Correction Response Letter  
Jordan Remodel

Address: 7058 82nd Ave SE  
Permit number: 2403-075

Main Floor Plan
 SCALE: 1/4" = 1'-0"

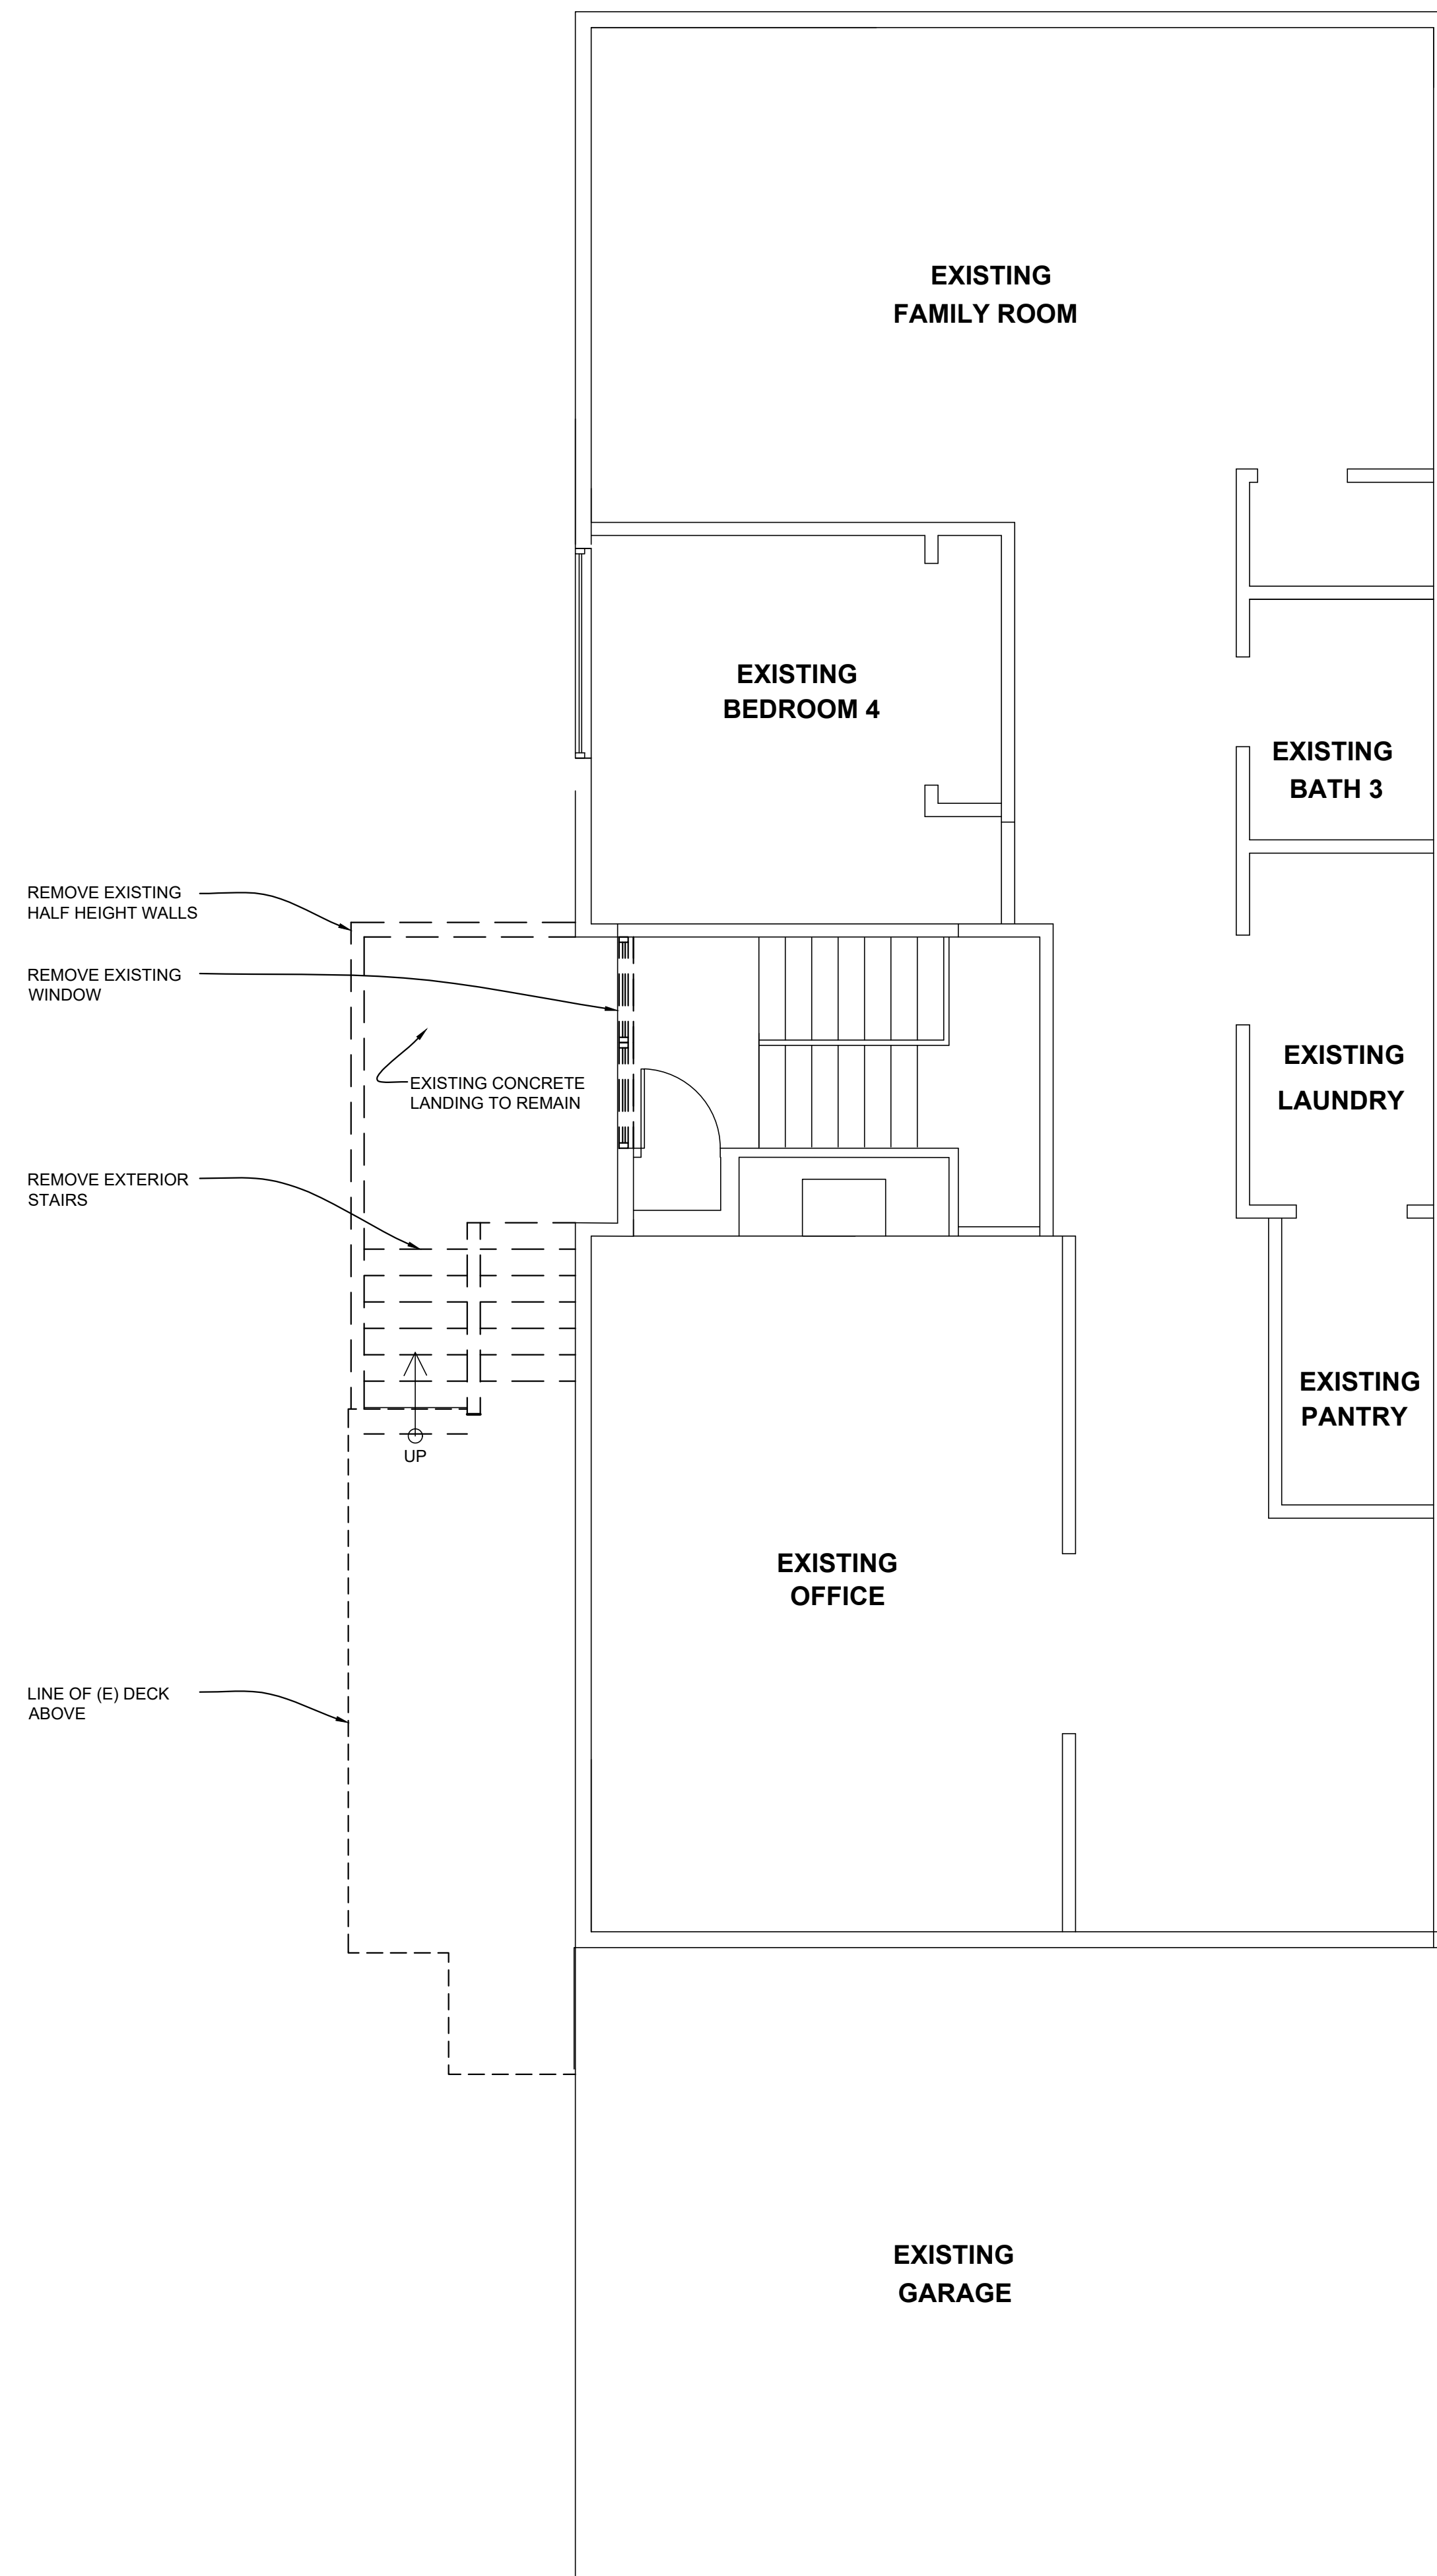
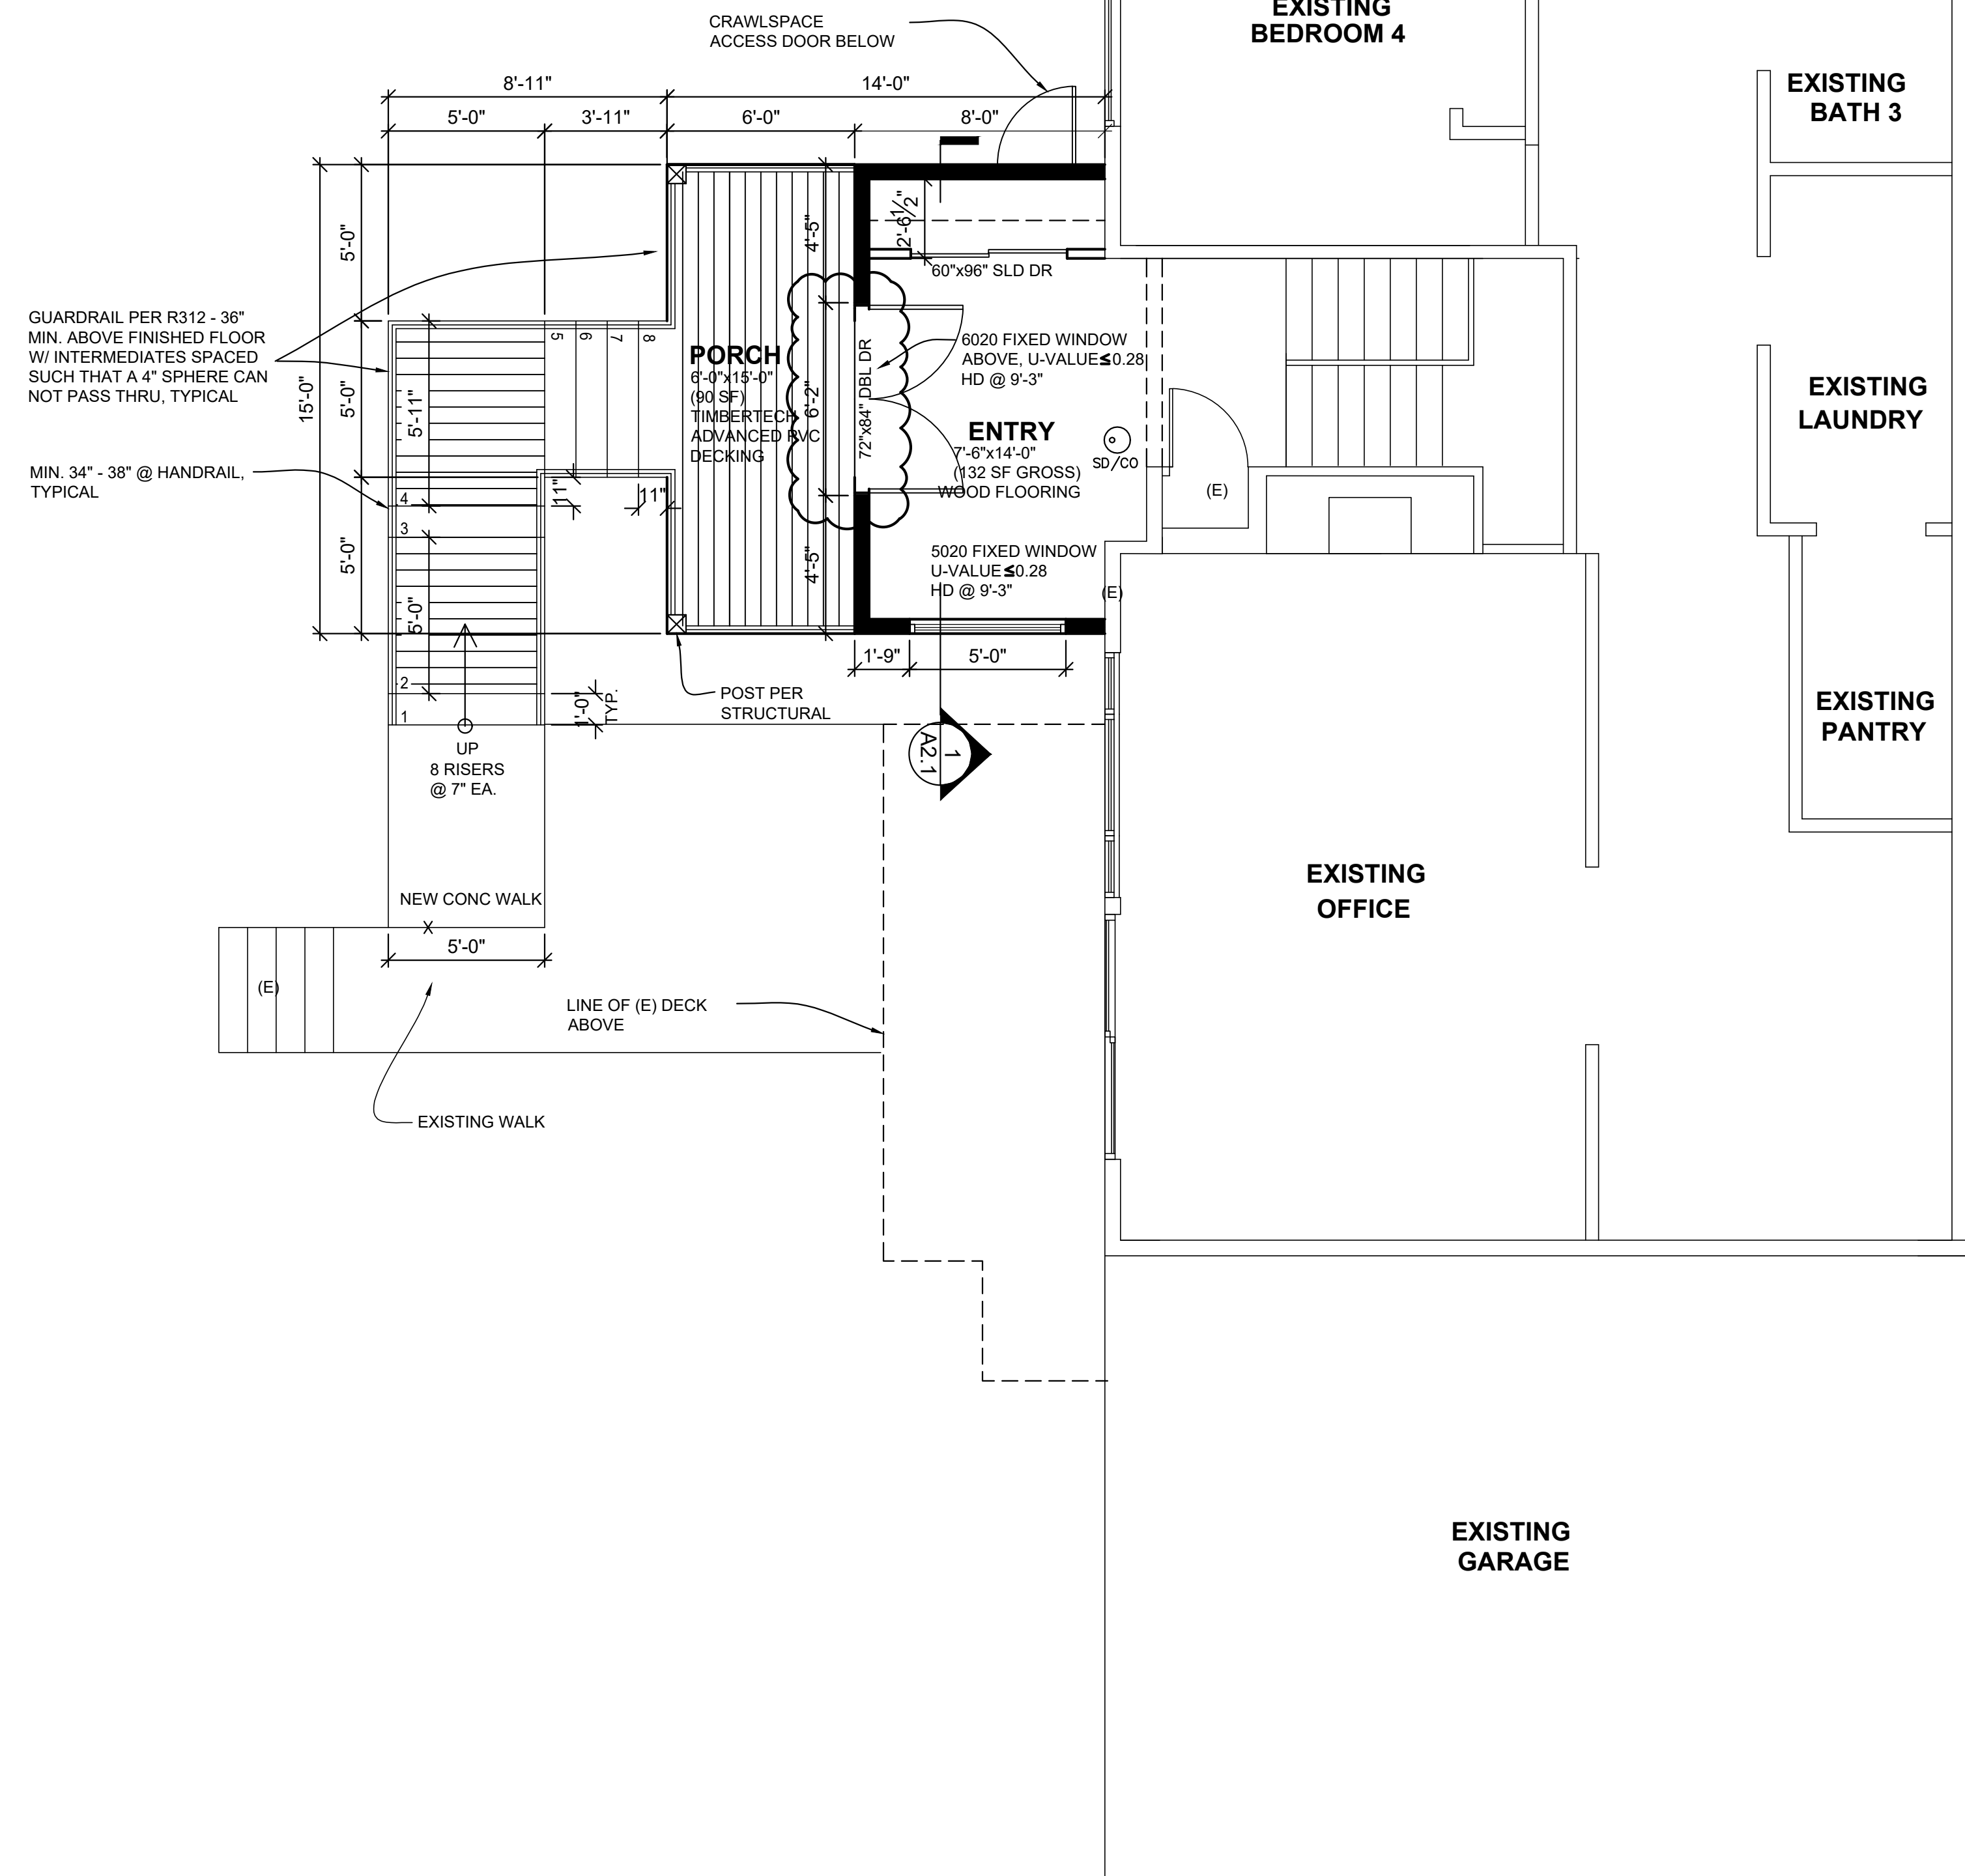
1. Please see the Structural Calculation
2. High Ledger Condition: Please see the structural plans.
3. We made a change to the front double doors to be 6' wide instead of 5' wide.  
Please see A2.0 and A2.1.
